Our Ref: 70058541 28 February 2020

Great Wolf Resort, Bicester: WSP Reponses to comments from CDC Ecology Officer 05 February 2020

The following outlines our response to the comments provided in correspondence of 28th January 2020 by Dr Charlotte Watkins (Cherwell District Council's Ecology Officer) to Clare Whitehead, regarding the application 19/02550/F for the Land to the East of M40 and South of A4095, Chesterton, Bicester.

Drawing Title: LANDSCAPE GENERAL ARRANGEMENT SHEET 4 OF 4

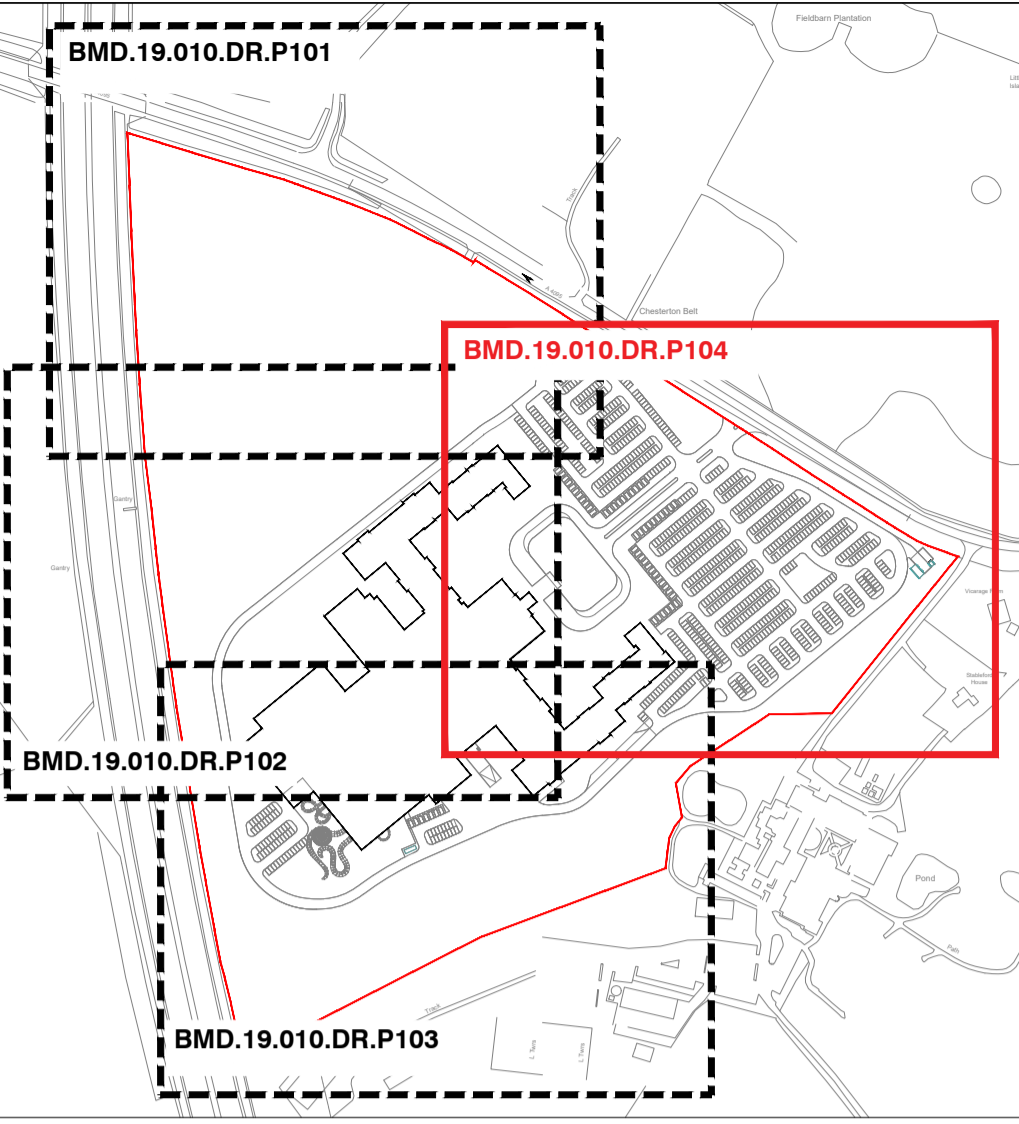
I can't tell if calculations for 'scrub' includes small areas of ornamental planting around the carpark which may be of limited value – these are marked as scrub in the post-development habitat map. Similarly with the low (1.2m) hedging proposed within the large carpark area. This should be clarified.	These areas are included in the net-gain calculation and were classified as dense scrub. This was considered more appropriate than other options such as hedgerow. Notwithstanding, we add that this part of the site (those habitats within the vicinity of the new buildings and car park) contribute approximately 9.7 units to the post development total of 70.9, which overall delivers a net gain of 15.1 units. If this unit contribution were to be reduced, the scheme would continue to deliver a net-gain in biodiversity.
The large strip of amenity grassland to the Southern edge of the buildings would be better replaced with other grassland which would better maintain a wildlife connection between the (current) two halves of the golf course.	This comment is appreciated, and the applicant is happy to agree to this. As part of a final landscape plan (to be secured by way of planning condition) we will need CDC approval working with CDC Ecology and Landscape officers. Any change represents an improvement in the biodiversity net gain calculation and we therefore assume is welcomed.

CDC Ecology Officer Comment	WSP Response
In addition, the area is shown as being lit at night and I would question the need for this? This area should be kept dark to maximise its value to biodiversity, limit light intrusion for bats and maintain dark corridors around the site. Similarly with lighting there are plans to light up trees – this should be avoided due to its potential impact on the use of trees by nocturnal species. Lighting on the building should be designed with integrated bat/bird provisions in mind.	Lighting is only proposed in the immediate environs of the hotel and car park. This is necessary for operational and health and safety reasons. The contribution of the bollarded lighting and tree illumination would be minimal in the context of the roads and car park to be illuminated. We suggest that locations for bat and bird boxes are reviewed as part of a detailed landscape condition (which we are happy to be a pre- commencement of development condition), to allow consideration alongside detailed designs for lighting, again this will be the subject of detailed approval by way of discharge of a planning condition.
